From: guy walker [REDACTED]
Sent: 30 May 2019 11:35
To: Daun Johnson
Subject: Re: FW: 1-2 The Parade Argyle Road Bognor Regis BR/125/19/PL

The proposed second floor plan and west elevation does not accord. The floor plan is showing two separate windows for the kitchen of the studio flat while the elevation only shows one window.

project title
1-2 Argyle Road, Bognor Regis
drawing title
Existing Elevations

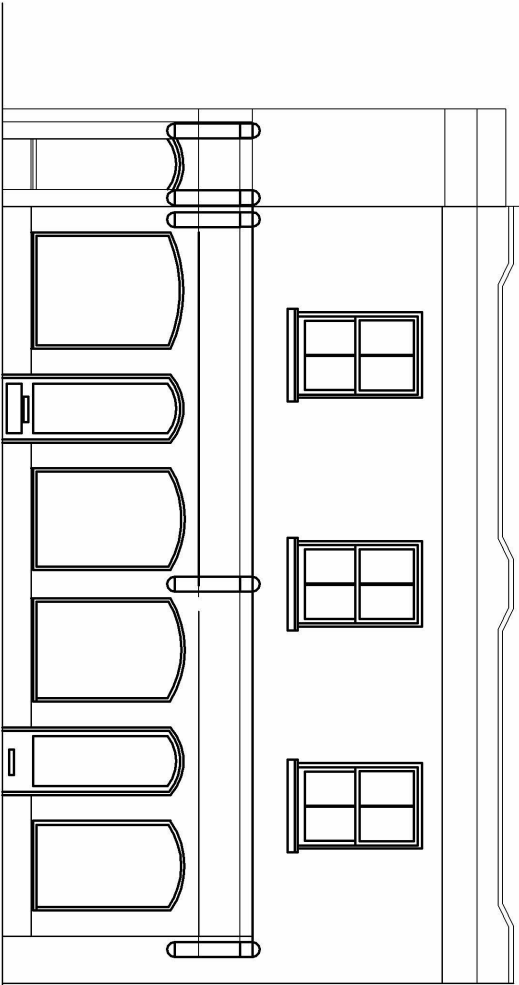
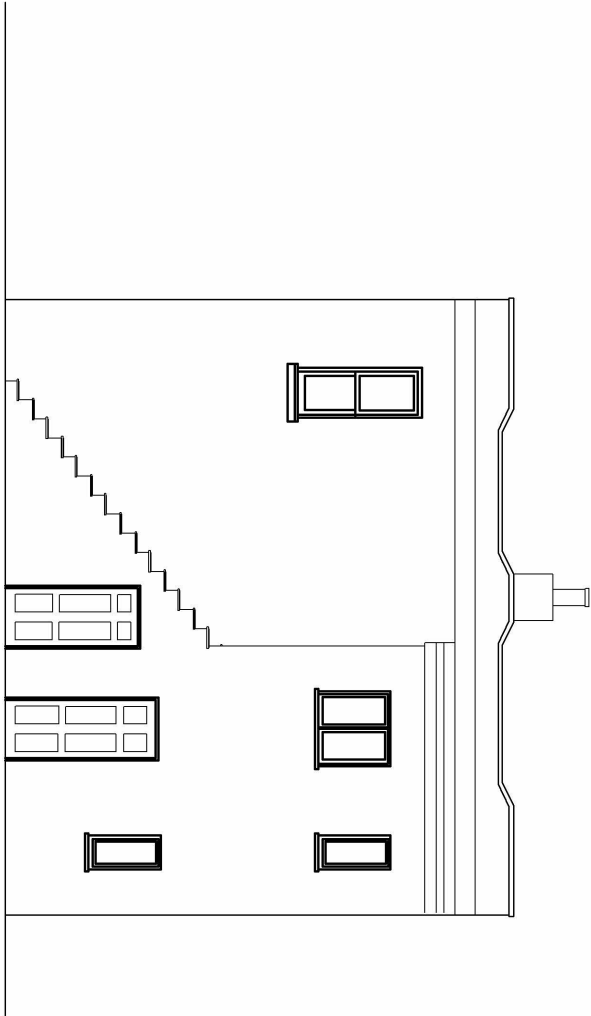
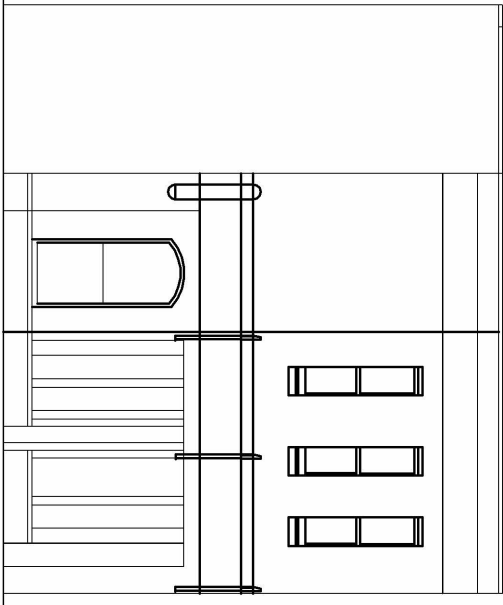
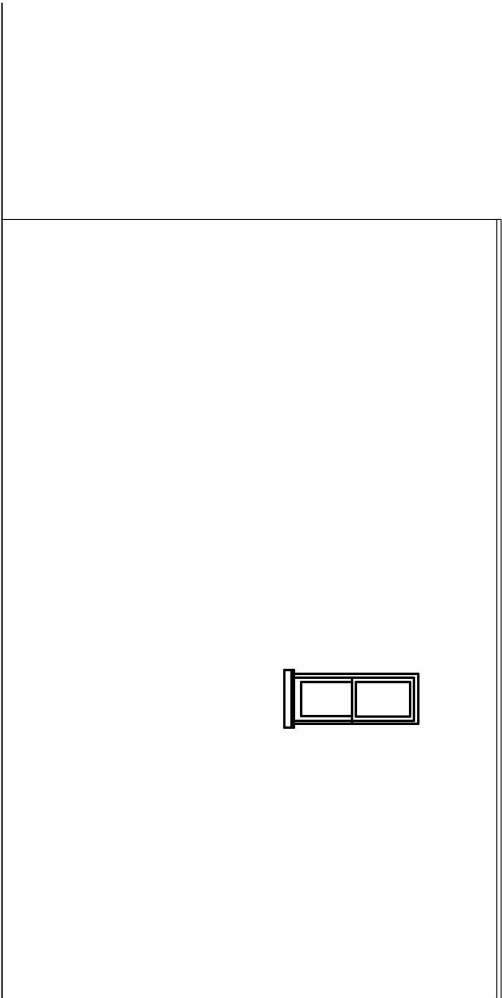
I have just looked over the plans. On the existing south elevation and first floor plan, a window for the lounge is not on the floor plan.

| drawing title | Proposed Elevations           |

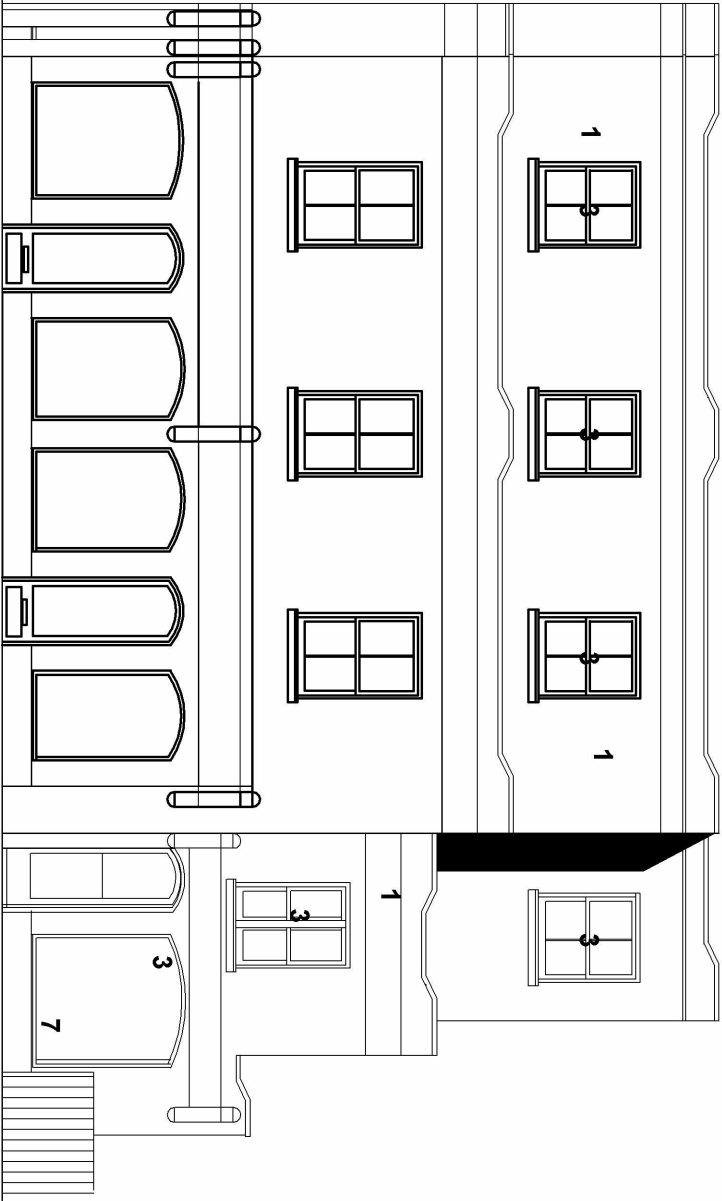
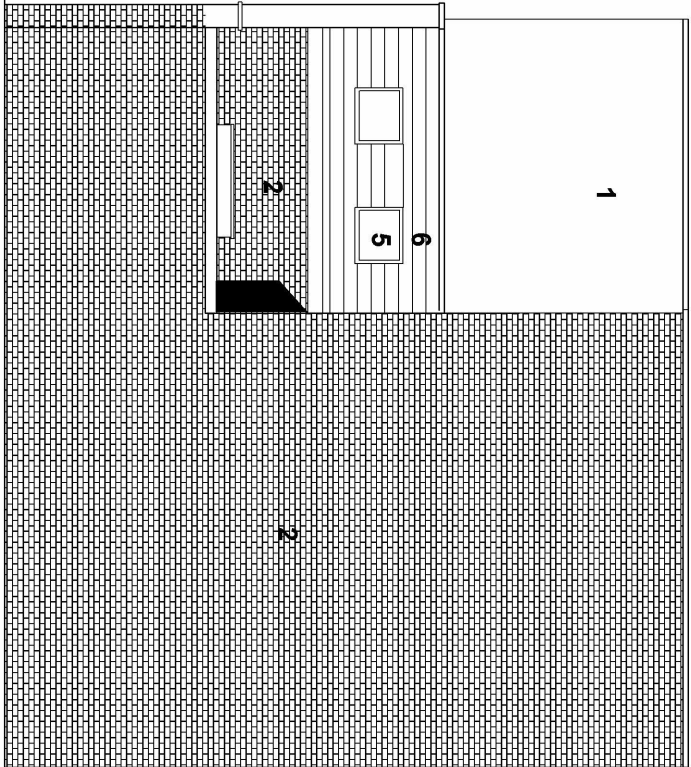
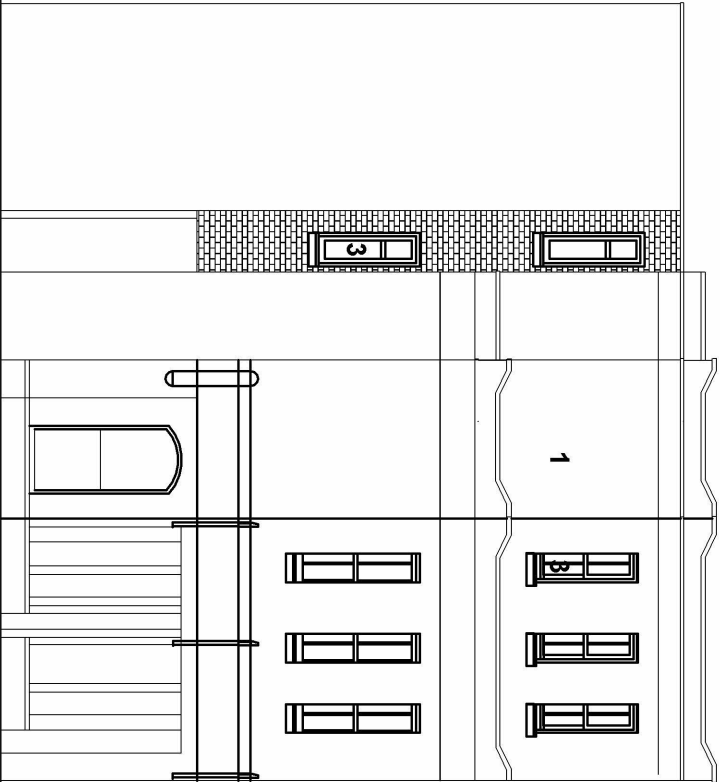
A window appears on the proposed first floor east elevation that doesn't appear on the proposed first floor plan.

In relation to the proposed west elevation the second window does not appear as if is hidden by the existing west elevation.
